KIRKLEES METROPOLITAN COUNCIL INVESTMENT & REGENERATION SERVICE

DELEGATED DECISION TO DETERMINE APPLICATIONS FOR LISTED BUILDING CONSENT

Reference No:	2024/65/92342/W
Site Address:	3, Lockwood Scar, Lockwood, Huddersfield, HD4 6BL
Description:	Listed Building Consent for alterations to dwelling to form 1 flat and 3 bed House in Multiple Occupation
Recommending Officer:	Katie Chew

DECISION – CONSENT GRANTED

Lower Ground Floor Plan

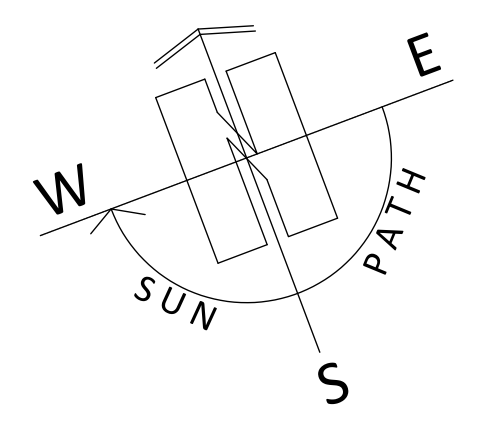
Amendments were made to the scheme to remove 1 of the originally proposed flats as this was to be located within the lower-ground floor of the dwelling, and as the site is within a Flood Zone 2 area, a self-contained flat in this location would not be acceptable.

Ground Floor Plan
Flat 1

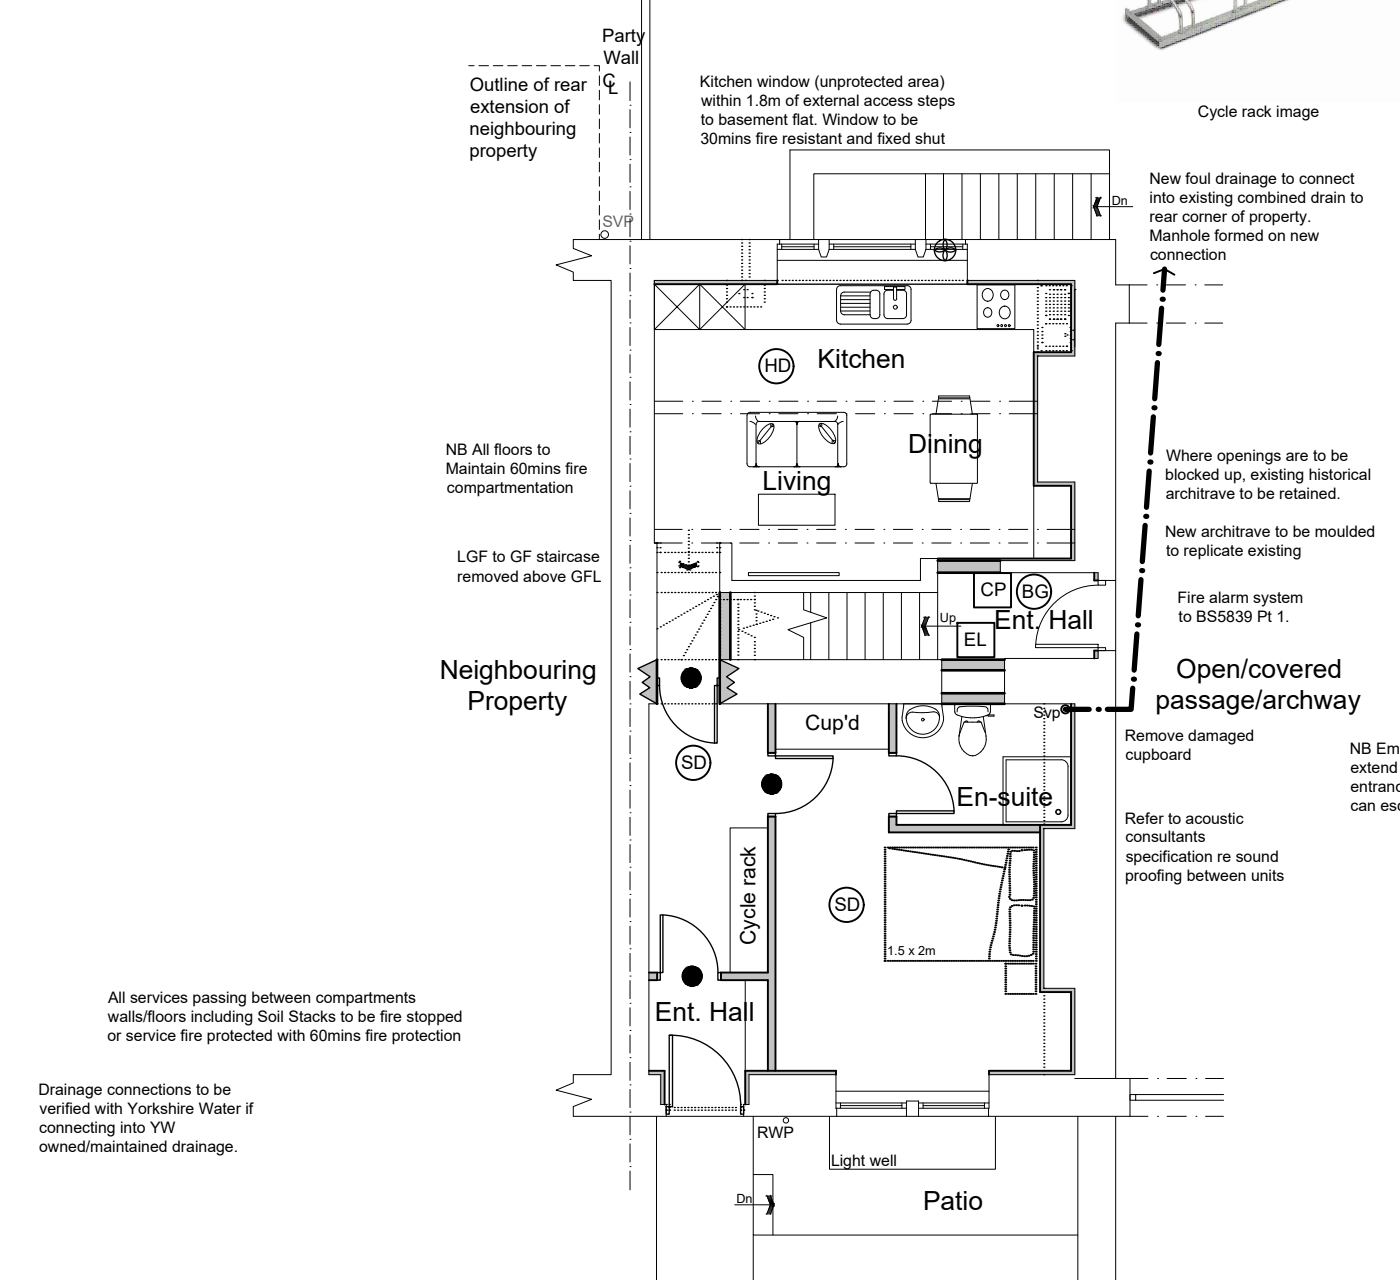
At ground floor level, the ground floor is currently accessed via a side entrance, with the front door leading directly into the front room permanently blocked up. The proposal is to reinstate the front door and subdivide this room to create a hallway leading into a front bedroom with bathroom, and a kitchen/ living room in the rear room. The side door will be used to access the first and second floors, and to provide a self-contained unit the existing doorways leading from the front and rear rooms into this entrance hallway are blocked up, with the architraves retained to show locations of the historic openings. Where new openings are formed, new architraves will replicate the existing. There is an impact on the historic plan form of the ground floor, however C&D Officers feel that the proposed alterations have been justified. To enable the building to have a viable use, it is accepted that some subdivision is required to ensure private access to the basement and ground floor flat, with separate access to the upper floor rooms.

5. Fireplaces and surrounds on both the ground and first floors of the host dwelling are to be retained, with the apertures blocked up and flue ventilation installed as necessary.

South Elevation
(front)

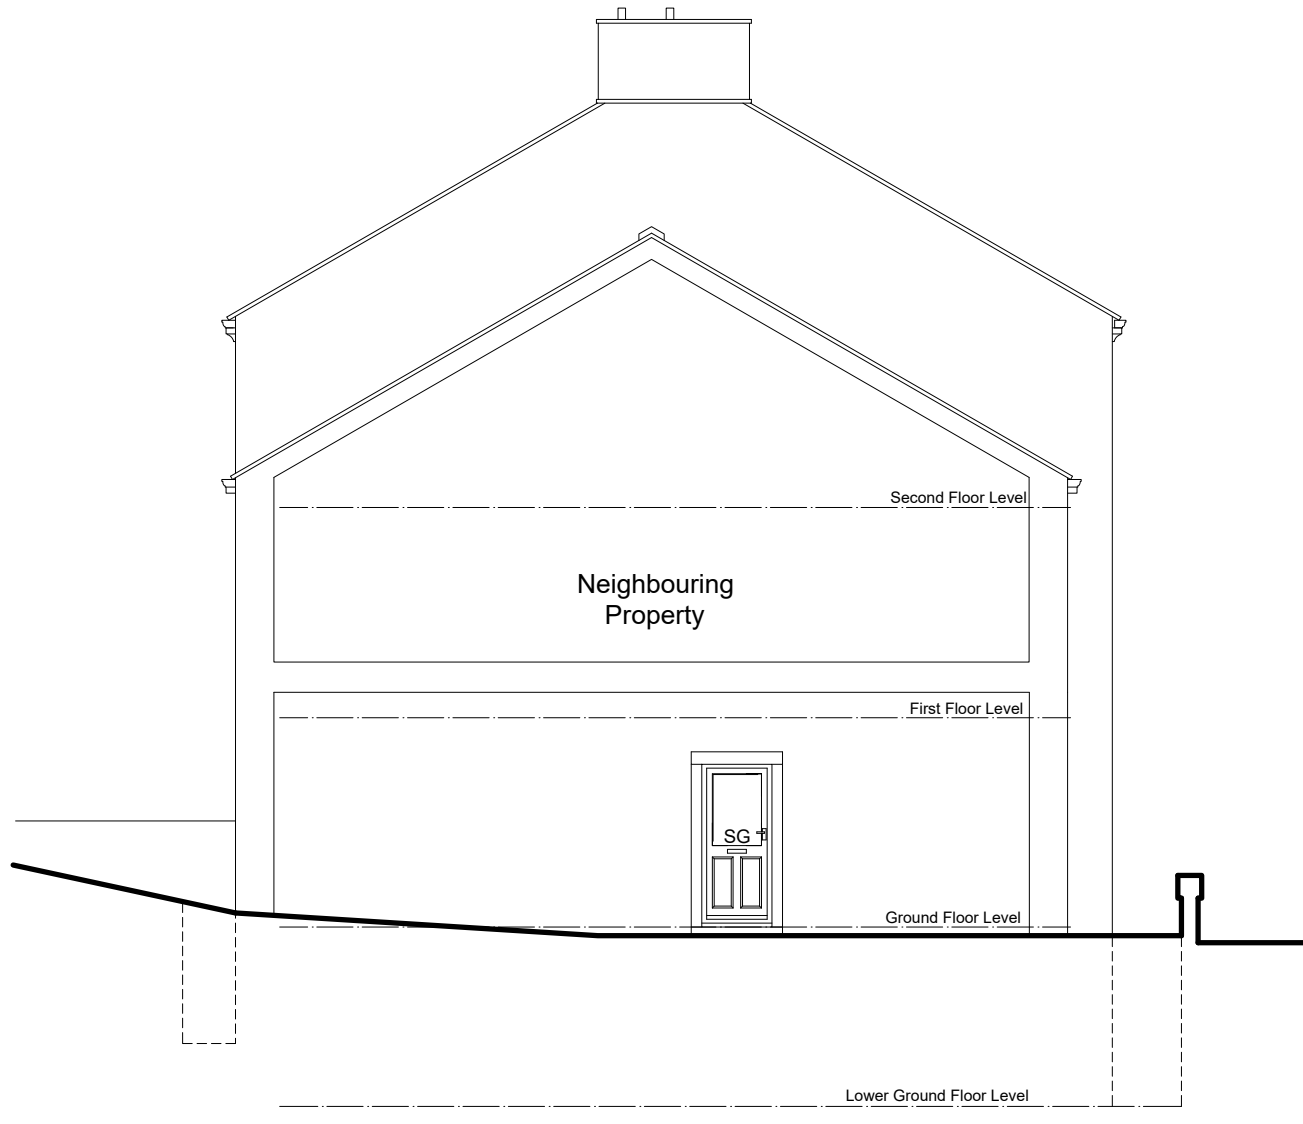
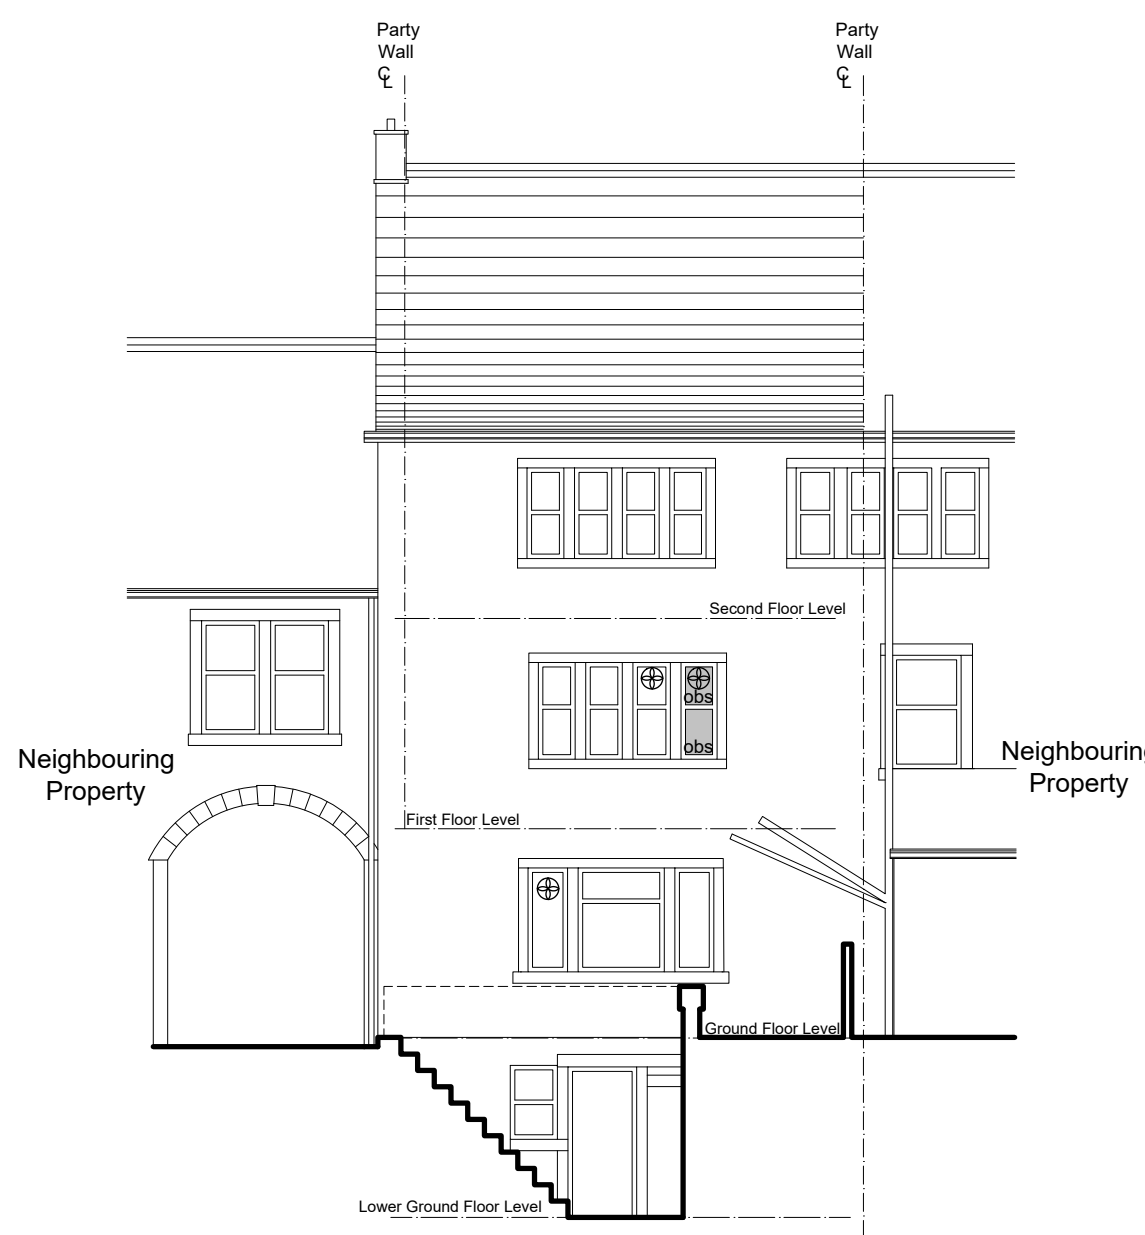
Externally, the replacement of the existing timber and uPVC windows with new timber windows with slim double-glazed units is proposed, with the replacement of timber and uPVC external doors with timber external doors.

3. Notwithstanding the submitted plans and information, full details of all windows and external doors to be replaced (1:20 elevations and 1:5 joinery details) shall be submitted to and approved in writing by the Local Planning Authority prior to their installation. Submitted information should include the window profiles, opening mechanisms, materials, slim double-glazing and colour. Obscure glazing is to be frosted and not patterned glass. The works shall then be carried out in complete accordance with the approved details.
